April 20, 2022

Gareth Reece
Senior Plans Examiner
City of Mercer Island Community Planning and Development

RE: Permit 2109-150 Correction Comment Responses
Site Address: 9611 SE 72nd Street

A400

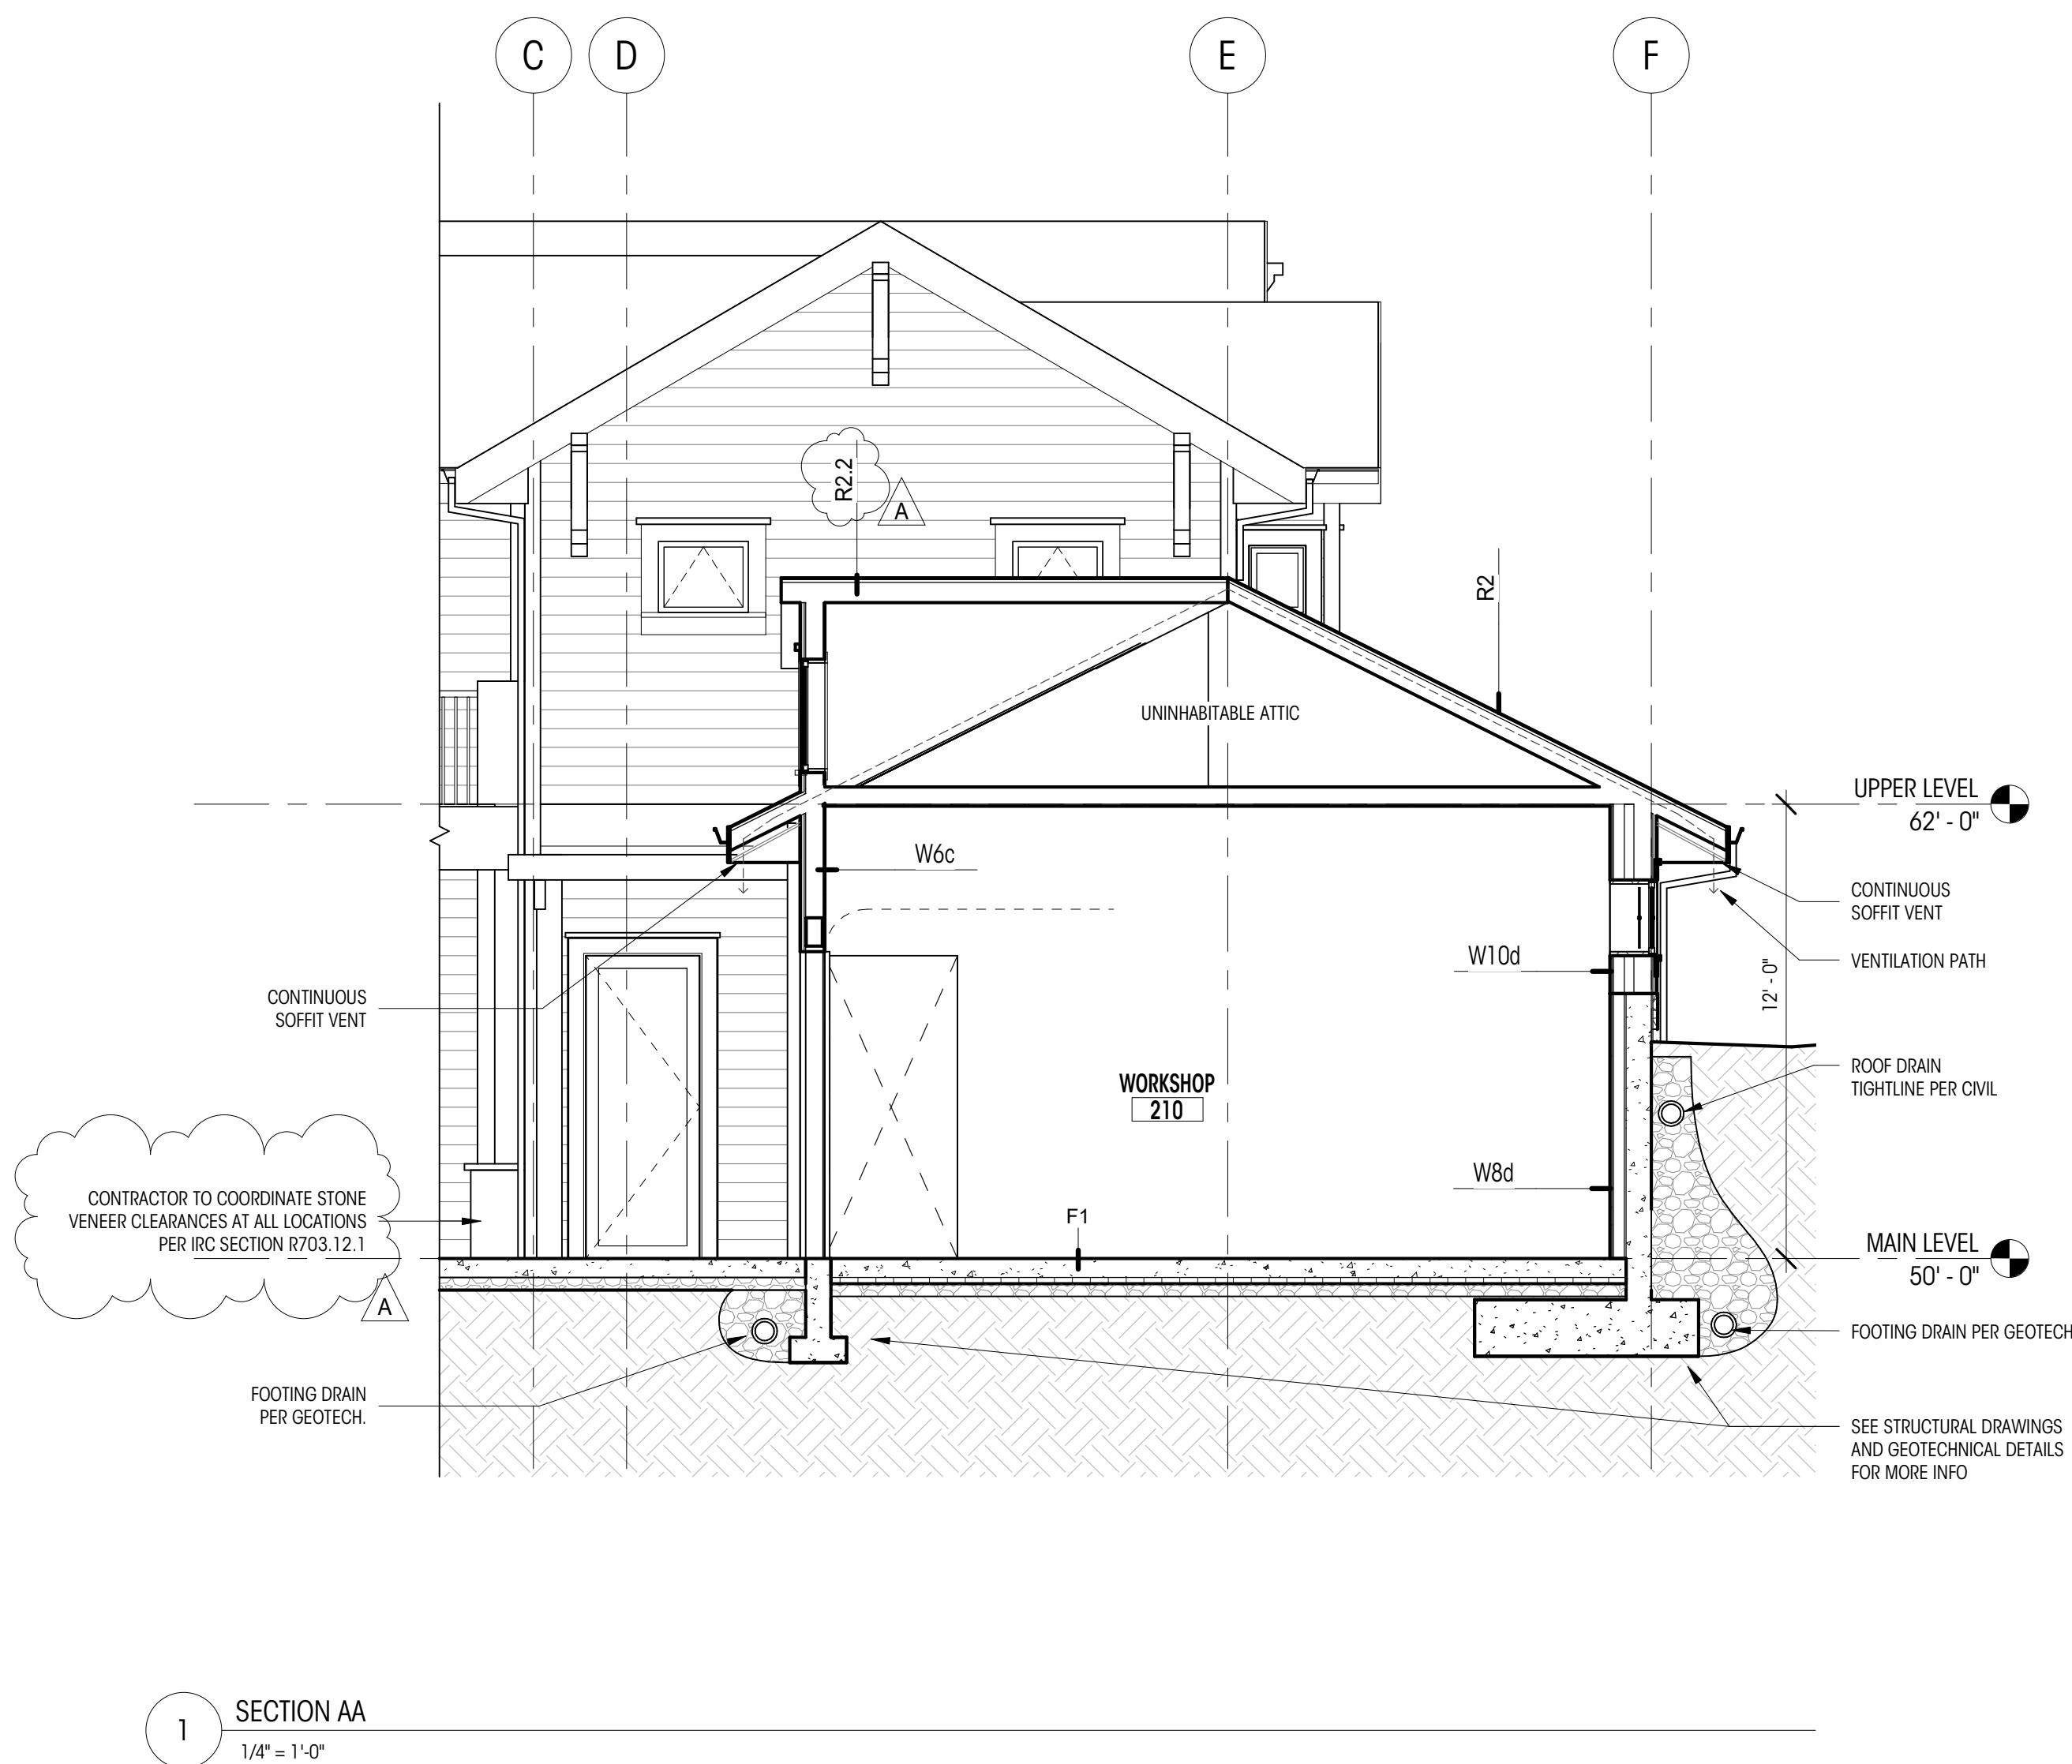
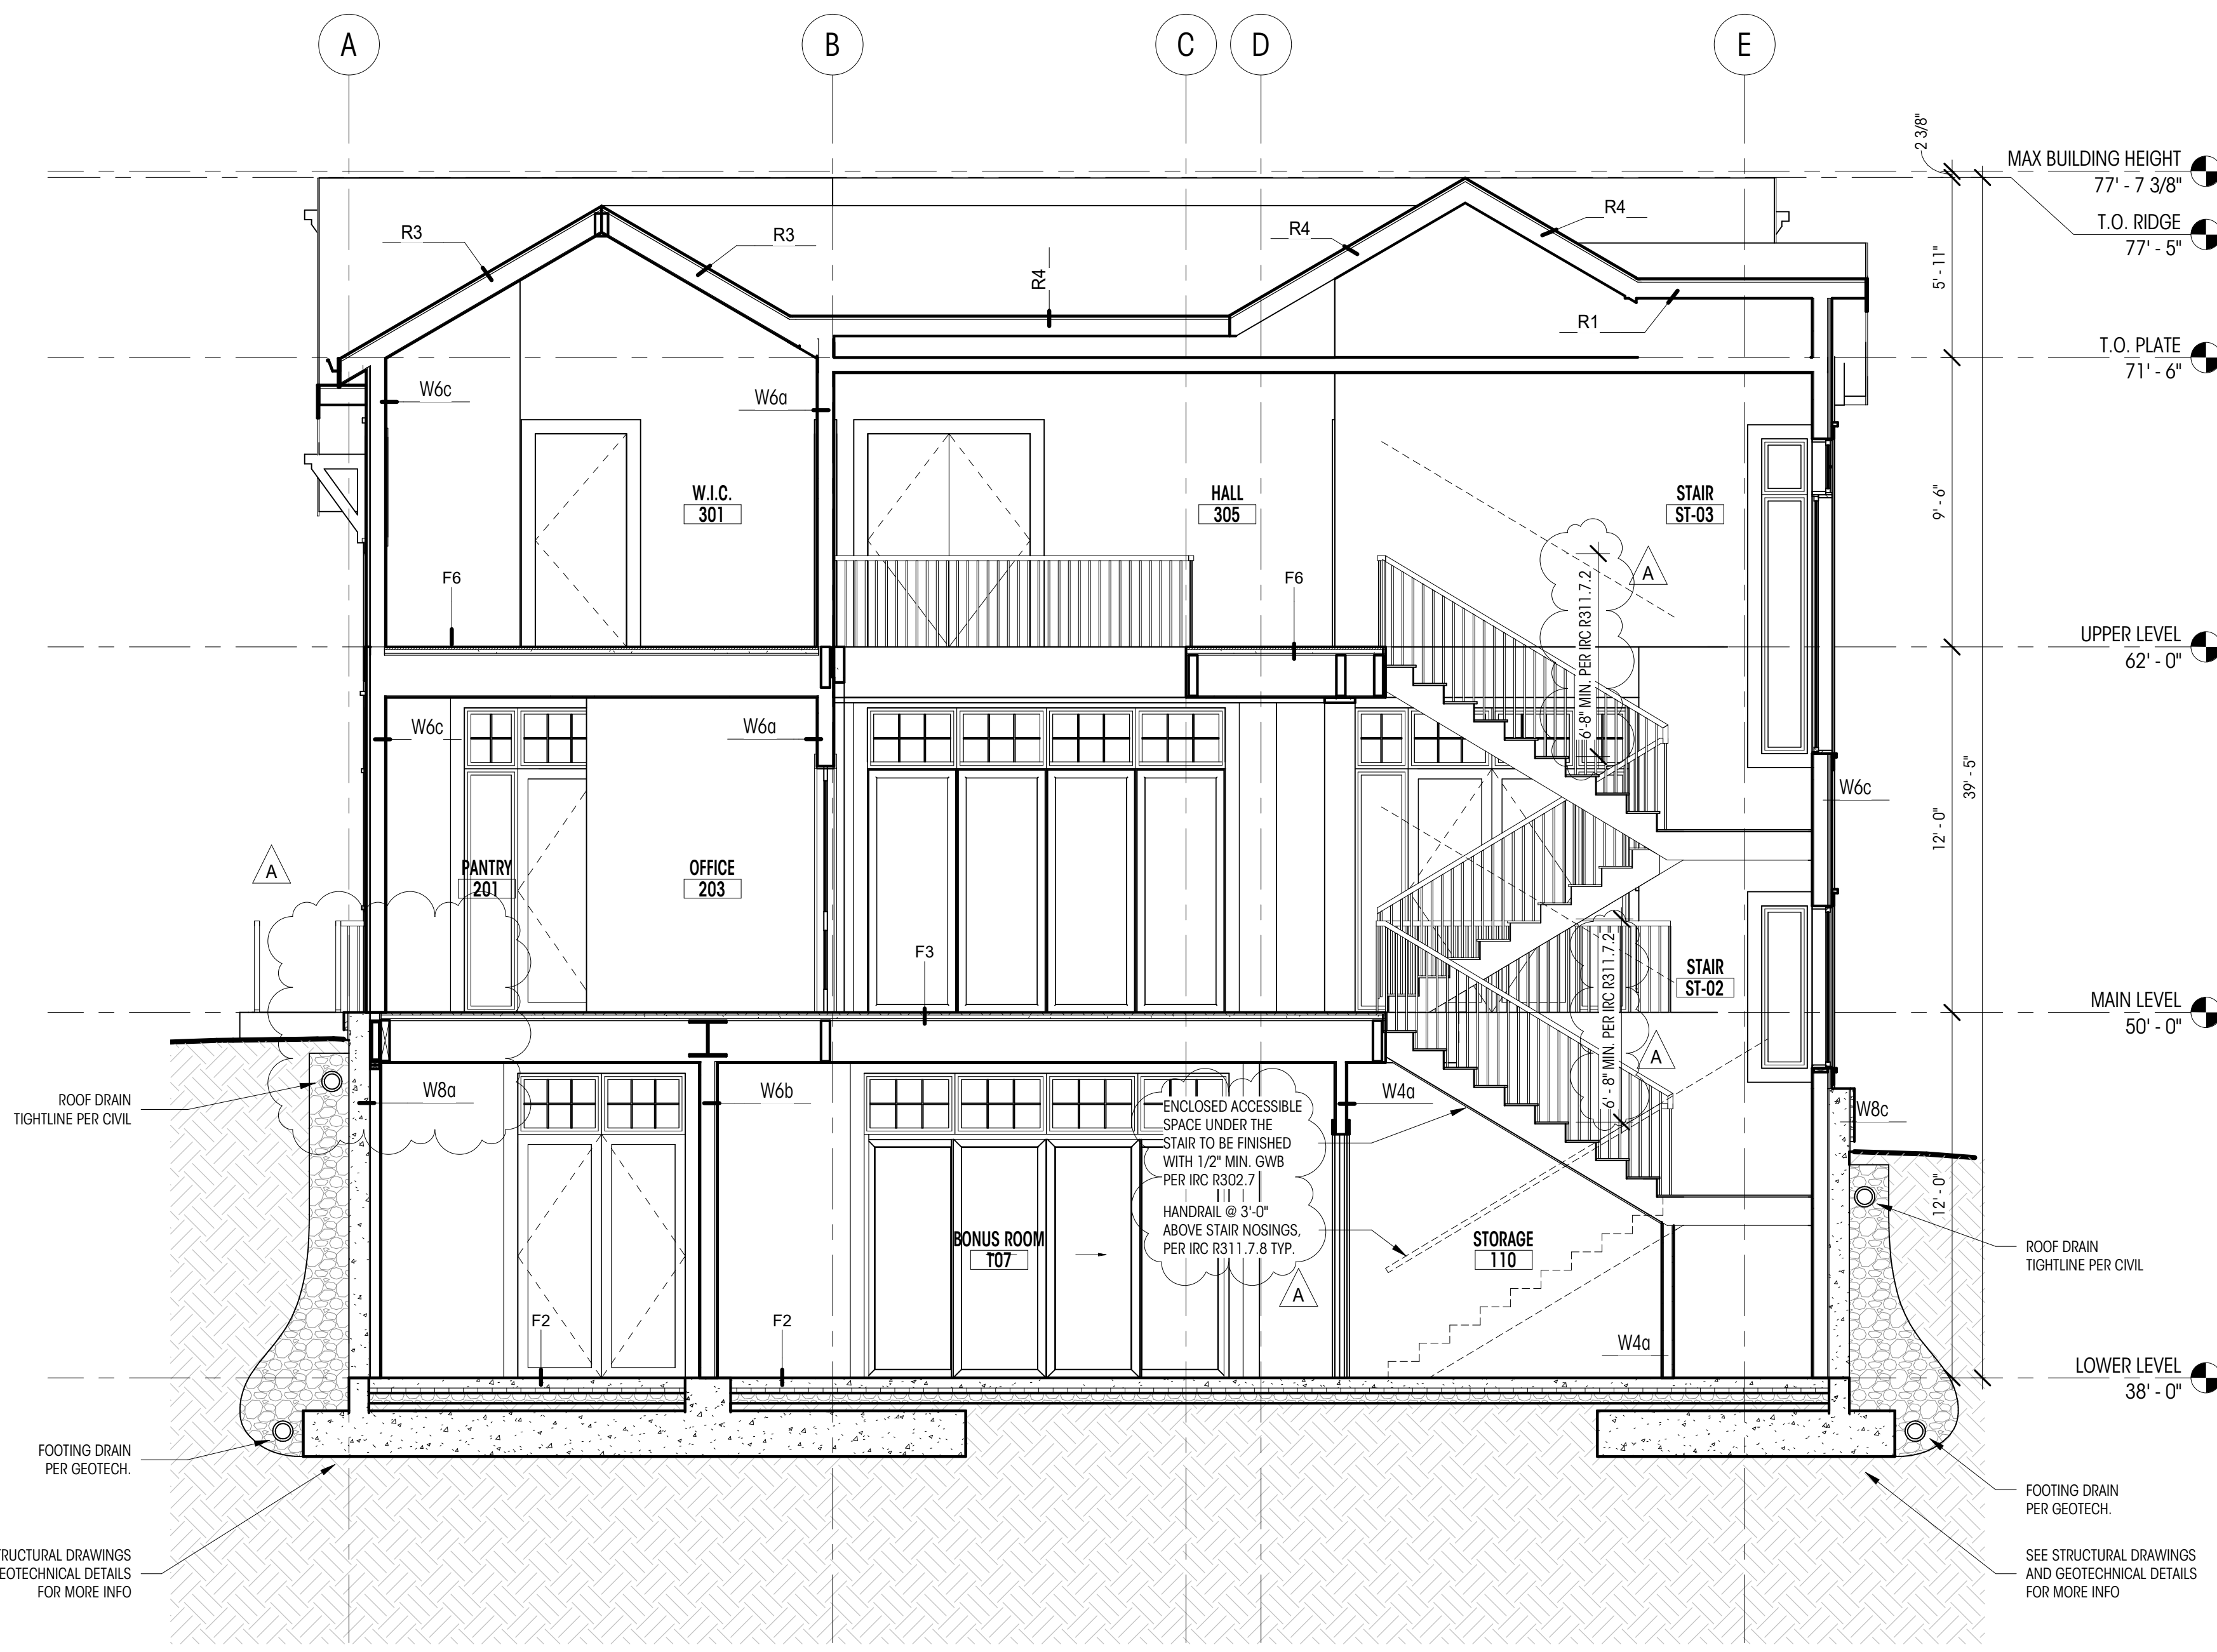
3. Enclosed accessible space under stairs must have walls, under-stair surfaces, and any soffits protected on the enclosed side with 1/2" GWB per IRC R302.7. Address this on the drawings.

5. Safety glazing is required where the bottom exposed edge of the glazing is less than 36" above the plane of the adjacent walking surface of stairways, landings between flights of stairs, and ramps per IRC R308.4.6 or where the glazing is less than 36" above the landing and within 60" horizontally of the bottom tread per IRC R308.4.7. Provide safety glazing at all ST-* windows.

Response: This has been noted on sheet A211 and A400.

Response: Glazing at windows ST-D, E, and F have a sill height of 30" and safety glazing has been noted on sheet A600. Glazing at windows ST-A, B, C, G, H and J is more than 36" above the adjacent walking surface at the landing and more than 60" from the risers therefore these windows do not need safety glazing. Dimensions have been added on sheets A300, A301 and A400.
